From: Joyce Christie <Joyce.Christie@Cherwell-DC.gov.uk>
Sent: Friday, August 4, 2023 12:36 PM
To: Imogen Hopkin <Imogen.Hopkin@cherwell-dc.gov.uk>
Cc: DC Support <DC.Support@cherwell-dc.gov.uk>
Subject: 22/03308/LB North Arms Wroxton

Change of use from public house to one dwelling (associated with approval 22/00256/F), single storey rear extension, internal and external alterations with Conversion of existing outbuilding to ground floor garage with first floor ancillary accommodation

D&A/Heritage Statement May 2023
D&A Supporting Statement June 2023
Planning Statement June 2023
New Drawings June 2023
(Reconsult sent 03.07.2023)

DRAWING No.
 22070/P11

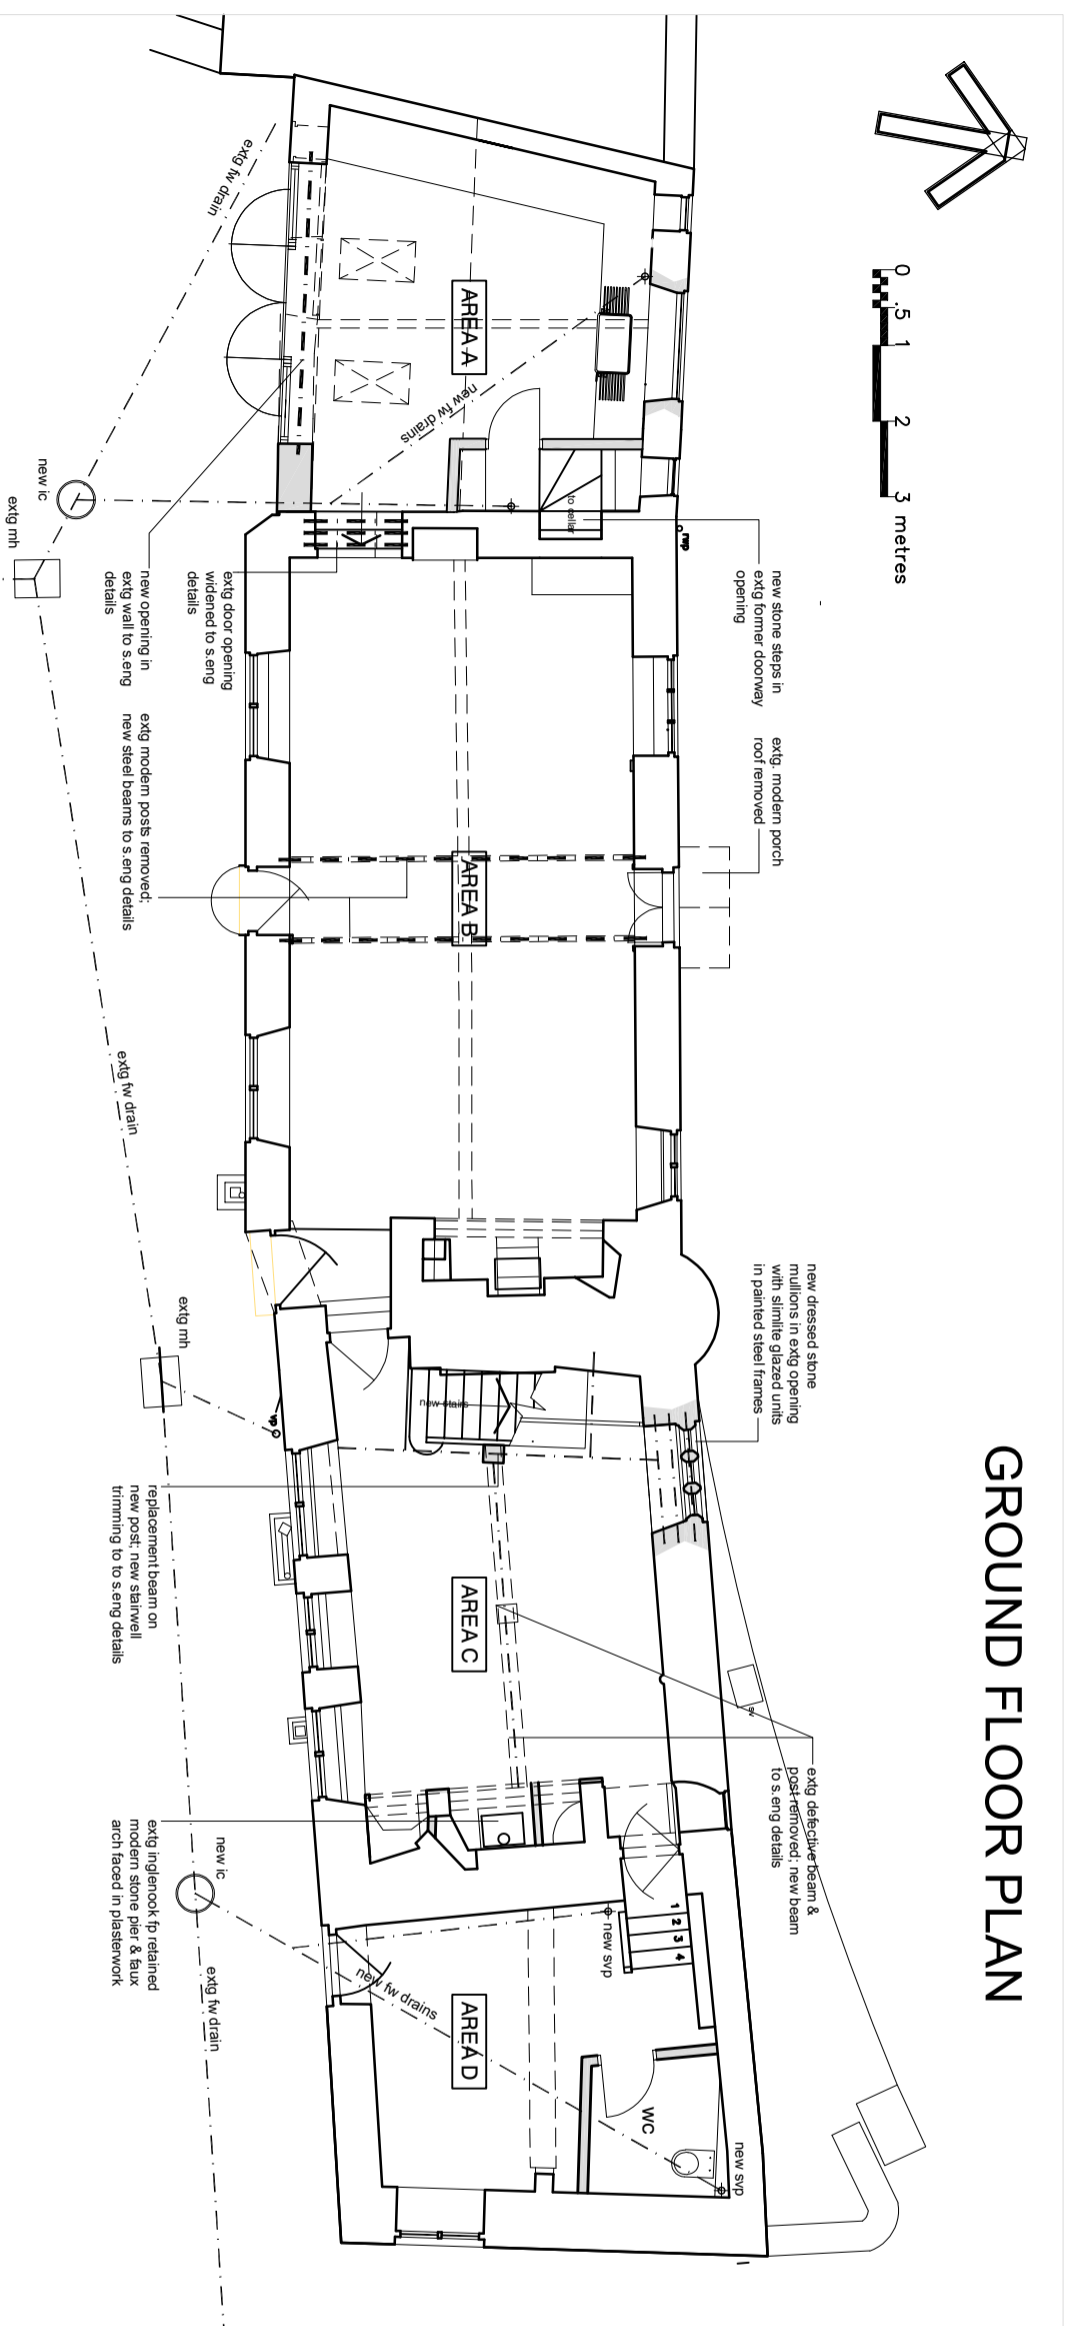
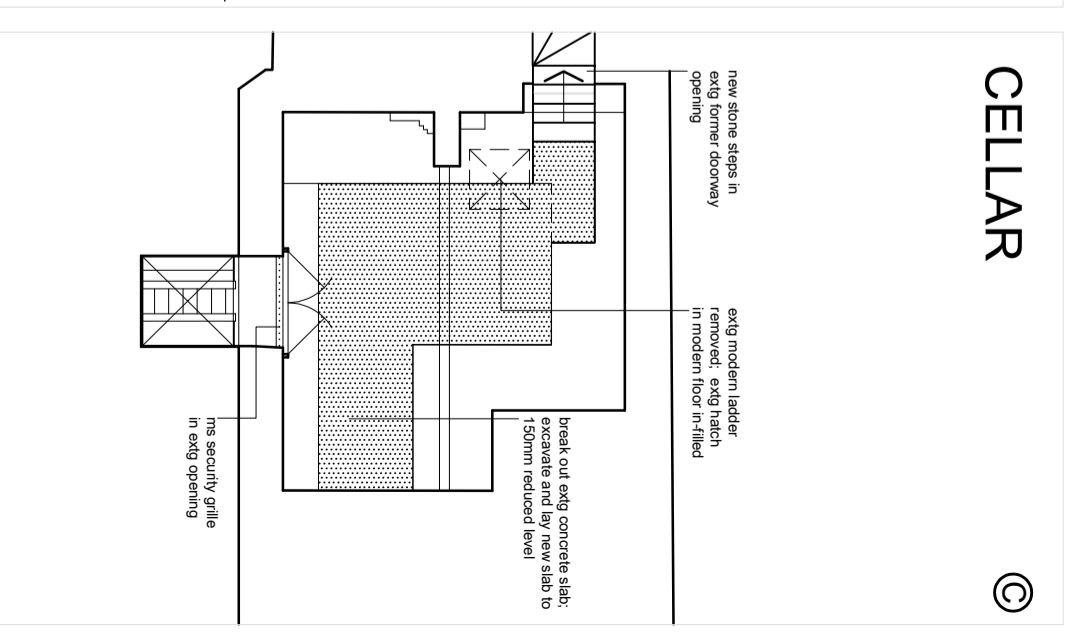
THERE ARE GENTLER MEANS THAN SANDBLASTING WHICH SHOULD BE EXPLORED. CONDITION SAMPLE CLEAN.
INSULATION – BREATHABLE INSULATION IS PREFERED IN HISTORIC ROOFS BUT THIS ROOF IS OF ON PARTICULAR SIGNIIIFCANCE.

THE LINEAR FORM OF THE PROPERTY IS A SIGNIFICANT PART OF THE CHARACTER OF THE LISTED BUILDING. THE MOST CONTROVERSIAL ELEMENT IS THE EXTENSION FORWARD OF THE BUILDING LINE, AND THIS IS **NOT SUPPORTED**. THE JUXTAPOSITION WITH THE BOUNDARY WALL AND GABLE ARE ALSO AWKWARD

CONDITION DETAILS FOR GLAZED SCREEN WHICH COULD BE INSERTED IN THE EXISTING WALL/OMITTING THE EXTENSION.

AS THIS IS A NEW ELEMENT WE WOULD ACCEPT WIDER DOUBLE GLAZING TO THIS SCREEN WITH EDGE SAPCERS TO MATCH THE COLOUR OF THE STEEL FINISH.

WHILST I WOULD PREFER LIMECRETE THROUGHOUT, THE PROPOSAL WILL NOT MAKE THE EXISTING SITUATION WORSE AS IT IS ASSUMED THE EXISTING IS CONCRETE WITH IMPERVIOUS TILES.

ENSURE EXCAVATION FOR NEW SLAB WILL NOT UNDERMINE FOOTINGS.

CONDITION DETAIL OF FIXING THE STEELS INTO MASONRY/METHOD STATEMENT.

CONDITION DETAIL OF ENCASING THE STEEL .

WIDENING OPENING – WHILST IT MAY BE WIDENED SLIGHTLY I HAVE SOME CONCERN WITH THE SMALL PIER OF MASONRY RETAINED BETWEEN THE OPENING AND THE FIREPLACE/CHIMNEY – **ENSURE AT LEAST 200 WIDE PIER REMAINS.**

AGREED SUBJECT TO A CONDITION FOR STRUCTURAL AND JOINERY DETAILS AND METHOD STATEMENT – WE WOULD EXPECT CONSERVATION REPAIRS AND STRENGTHENING OF EXISTING INFORMED BY AN INDEPENDENT DAMP AND DECAY SPECIALIST WHO IS NOT IN THE BUSINESS OF SELLING PRODUCTS.

CONDITION DETAILS FOR ANY NEW EXTERNAL PIPES/RWGS TO BE CAST IRON AND MECHANICAL VENTS TO FOLLOW COTSWOLD DC'S STONE SLATE VENT DETAIL IN WALL OR SUPPLY ALTERNATIVE DETAIL FOR EXTRACTS UNDER A DISC – LOCATIONS TO BE AGREED.

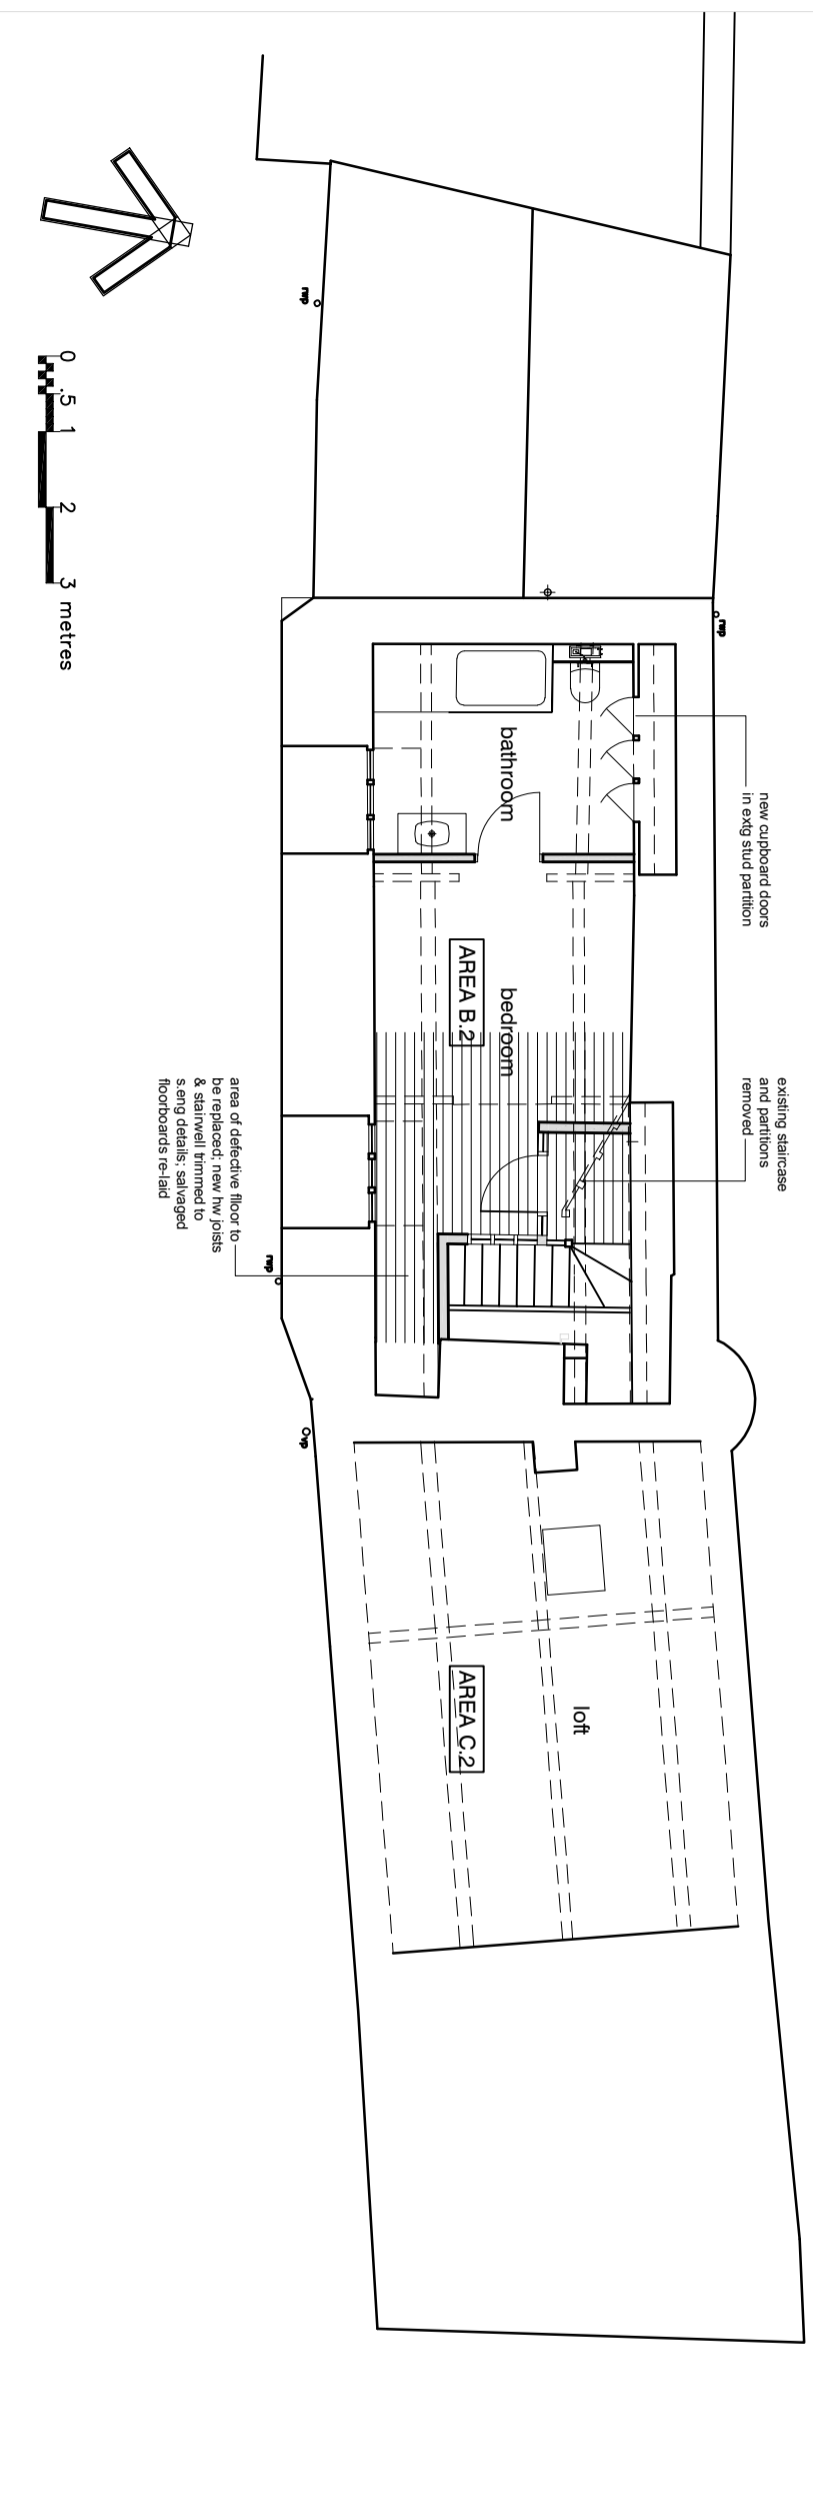
AVOID A CLASH BETWEEN NEW SKIMMED PLASTERBOARD PARTITIONS AND HISTORIC LIME – ALLOW FOR ROUNDED CORNERS.

CONDITION REFER TO SPAB GUIDANCE FOR OLD TIMBER FLOORS. AGREED SUBJECT TO A CONDITION FOR STRUCTURAL AND JOINERY DETAILS AND METHOD STATEMENT – WE WOULD EXPECT CONSERVATION REPAIRS AND STRENGTHENING OF EXISTING INFORMED BY AN INDEPENDENT DAMP AND DECAY SPECIALIST WHO IS NOT IN THE BUSINESS OF SELLING PRODUCTS.

CONDITION DETAIL OF BORROWED LIGHT. AVOID A CLASH BETWEEN NEW SKIMMED PLASTERBOARD PARTITIONS AND HISTORIC LIME – ALLOW FOR ROUNDED CORNERS.

DEFECTIVE FLOOR TO BE REPLACED **THIS SHOULD CHANGE TO REPAIR** BASED ON SPAB GUIDANCE ON FLOORS - **EMPHASIS ON REUSE**

CONDITION STRUCTURAL AND JOINERY DETAILS AND METHOD STATEMENT – WE WOULD EXPECT CONSERVATION REPAIRS AND STRENGTHENING OF EXISTING INFORMED BY AN INDEPENDENT DAMP AND DECAY SPECIALIST WHO IS NOT IN THE BUSINESS OF SELLING PRODUCTS.

22070/P14

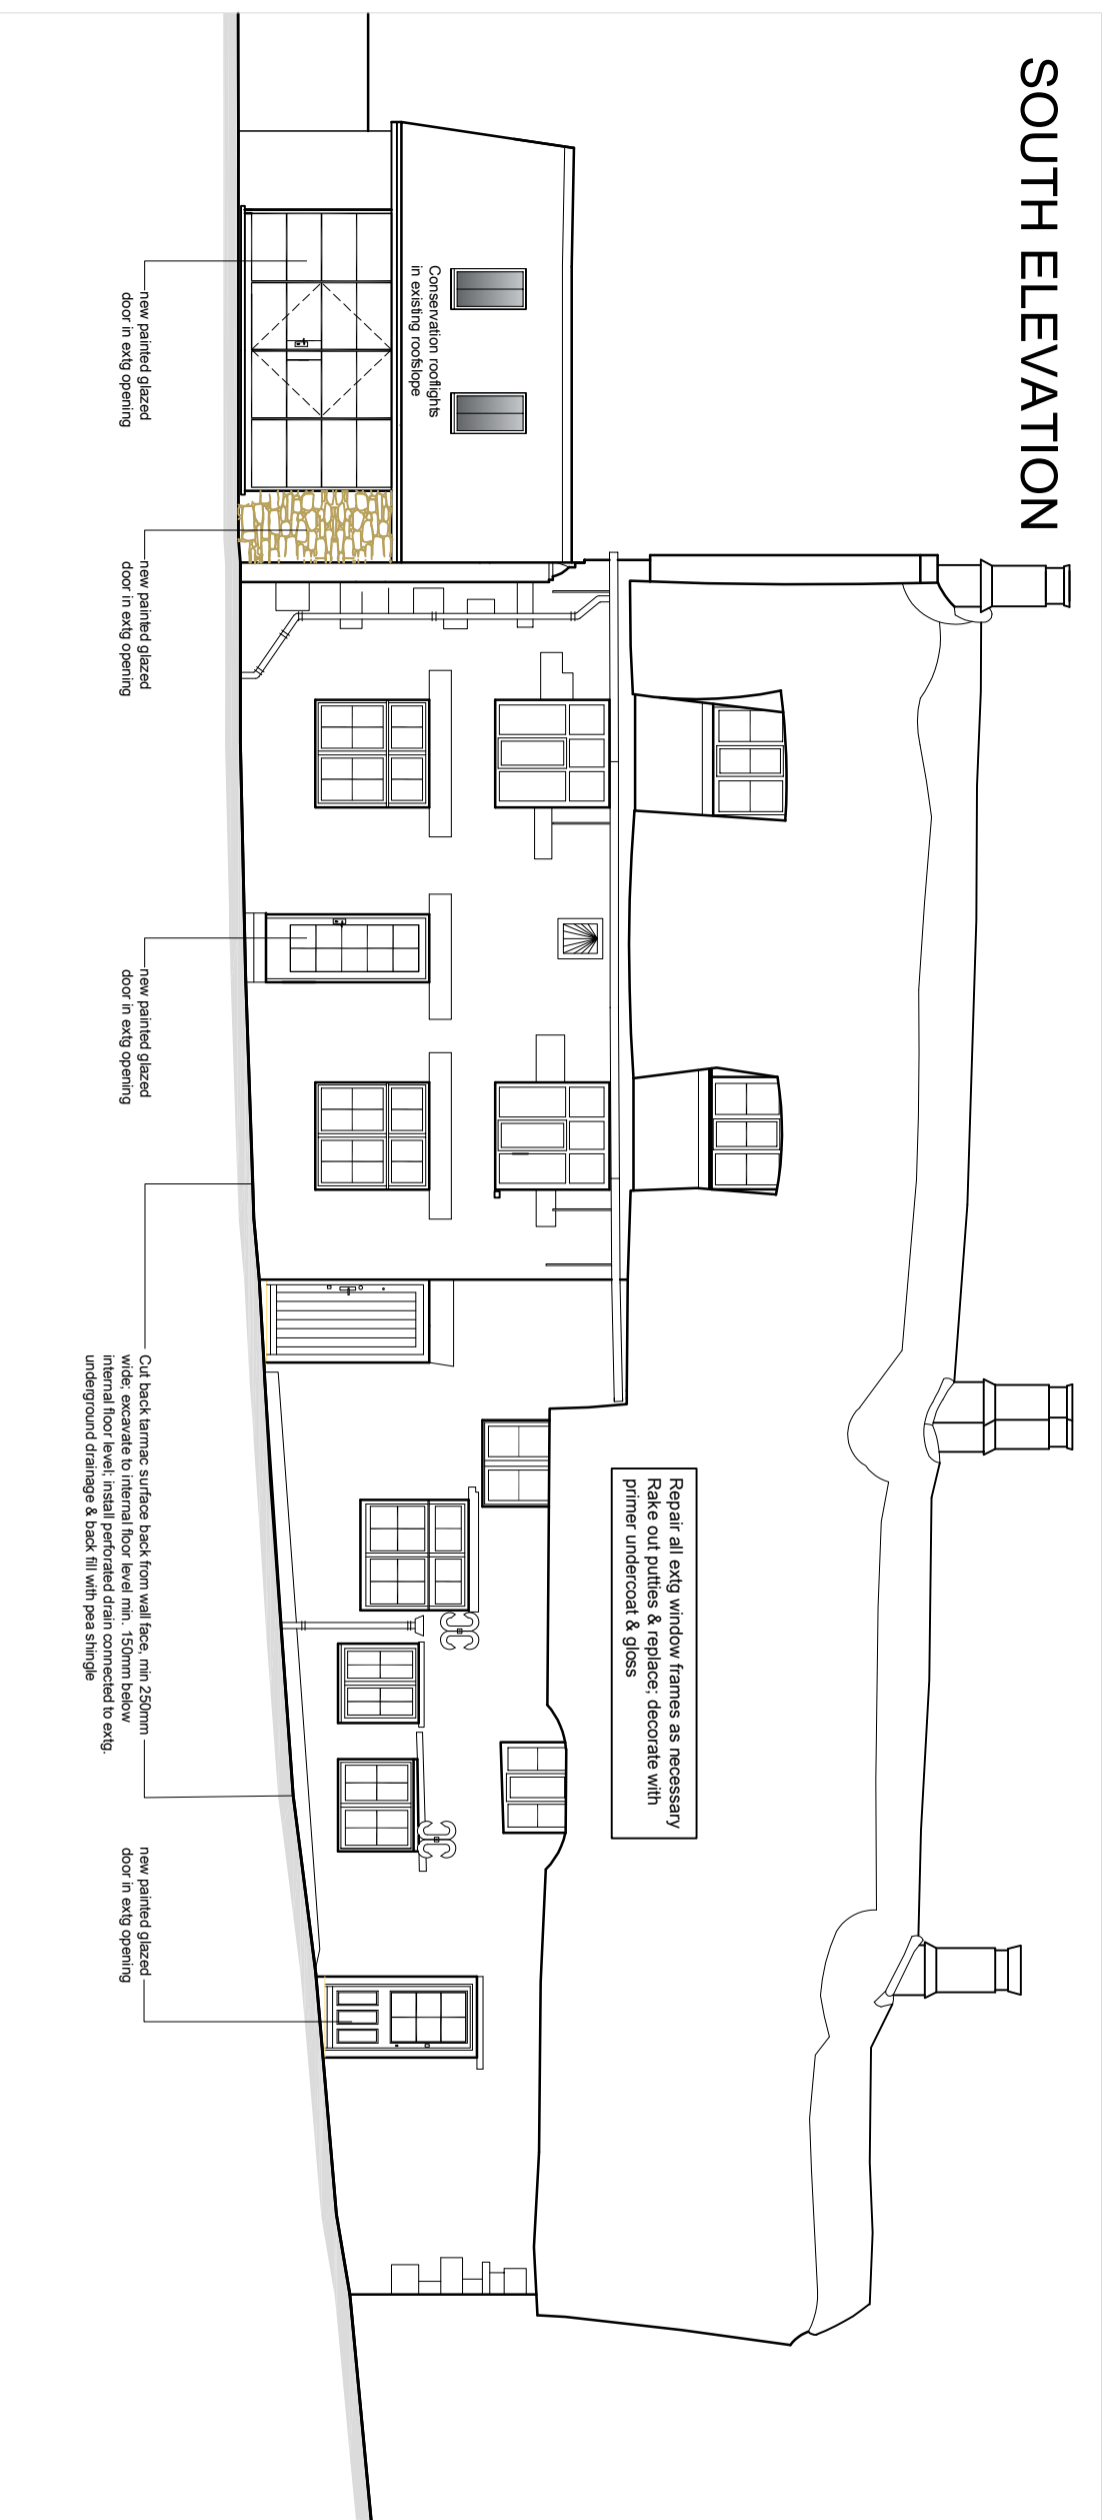
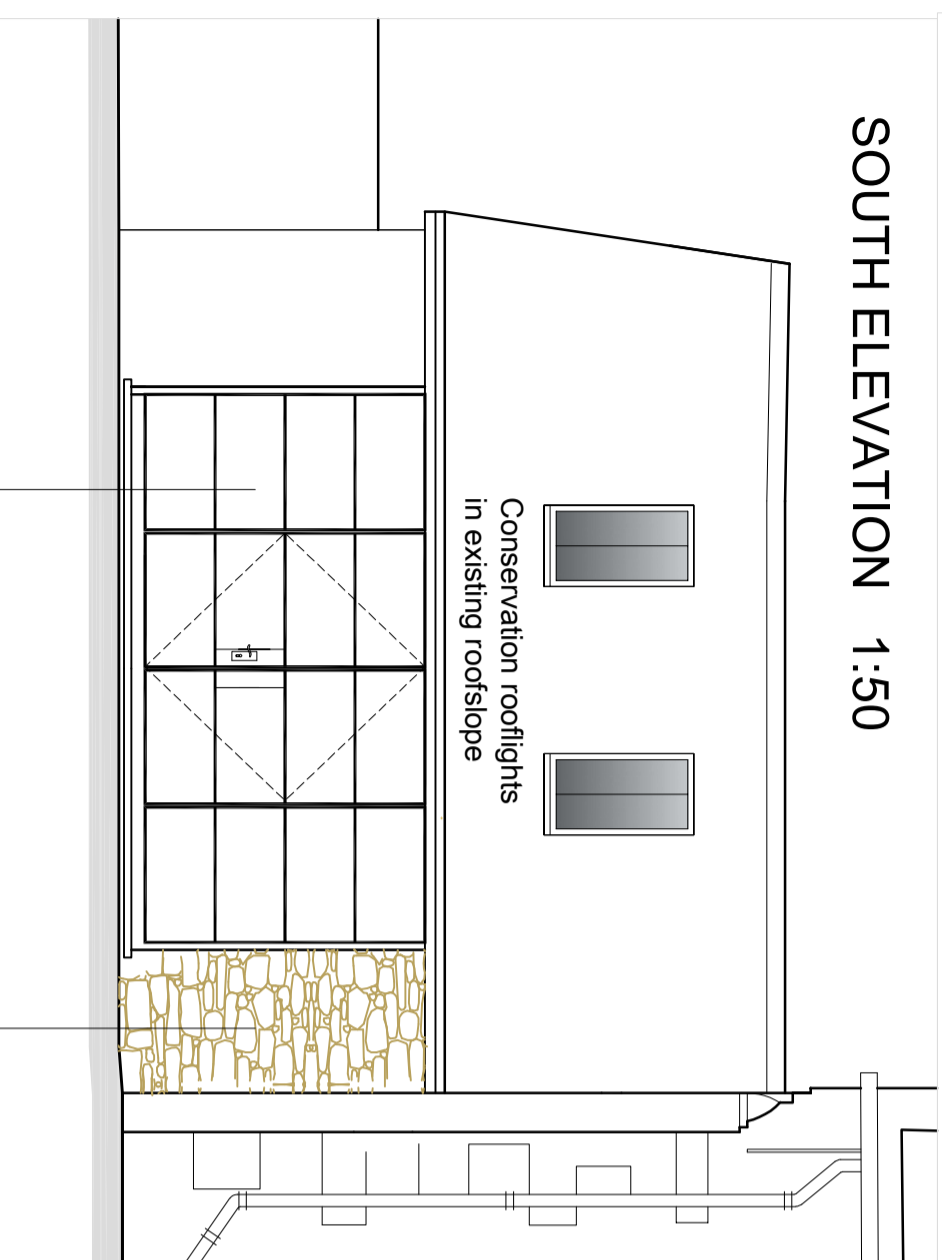
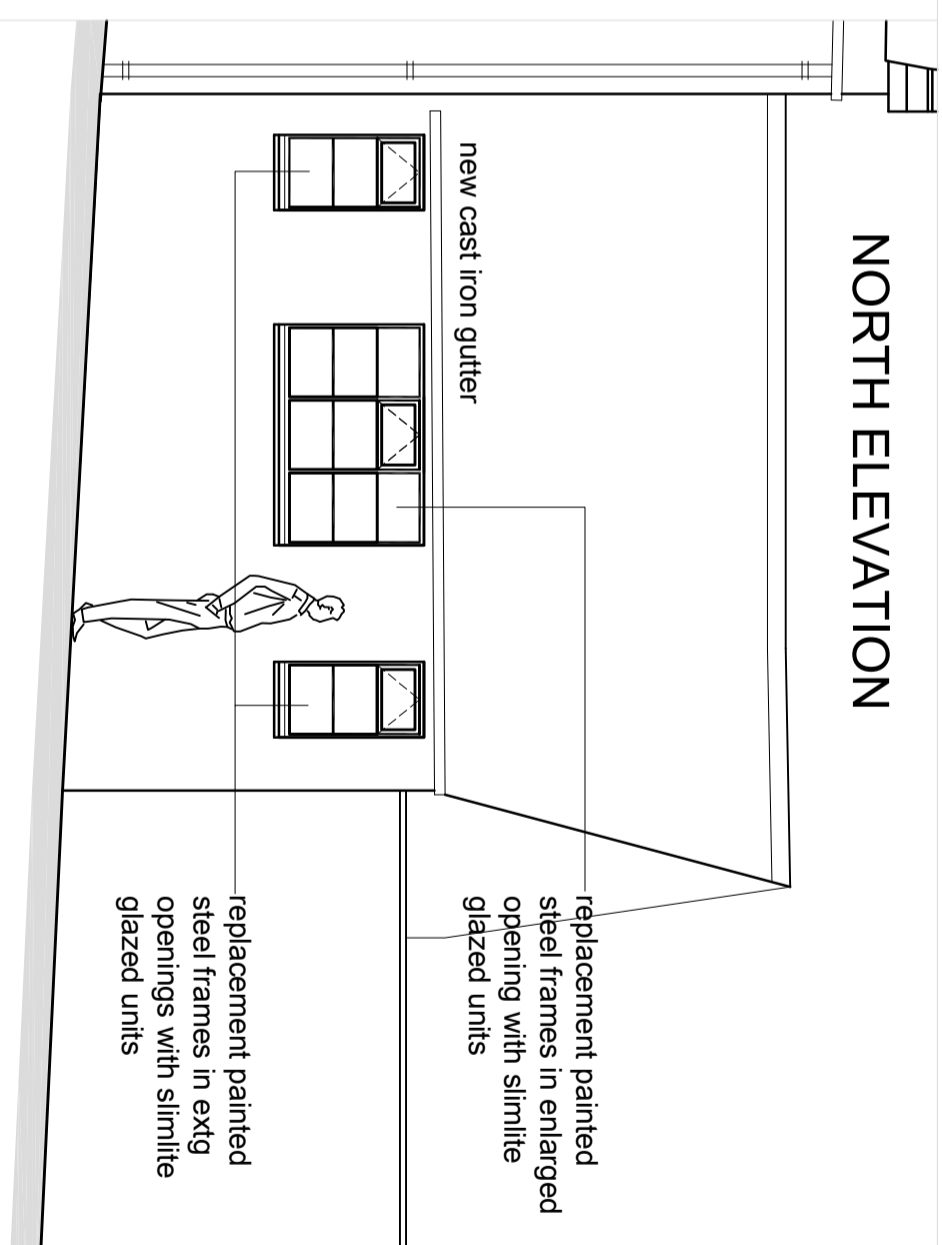
THE LINEAR FORM OF THE PROPERTY IS A SIGNIFICANT PART OF THE CHARACTER OF THE LISTED BUILDING. THE MOST CONTROVERSIAL ELEMENT IS THE EXTENSION FORWARD OF THE BUILDING LINE, AND THIS IS **NOT SUPPORTED**. THE JUXTAPOSITION WITH THE BOUNDARY WALL AND GABLE ARE ALSO AWKWARD. RECOMMEND THEY REVERT TO THE EARLIER PROPOSAL. – DETAILS WILL BE NEEDED. ENSURE A DECENT SET BACK FROM THE WALL FACE.

NEW GLAZED DOOR – THIS SHOULD BE AN AUTHENTIC GLAZED DOOR WHICH SUITS THE CHARACTER OF THE LISTED BUILDING. THE DOOR IS QUITE NARROW AND THE DETAILING NEEDS CAREFUL ATTENTION. A SOLID PANEL TO THE BOTTOM OF THE DOOR MAY HELP: DETAILS TO BE CONDITIONED.
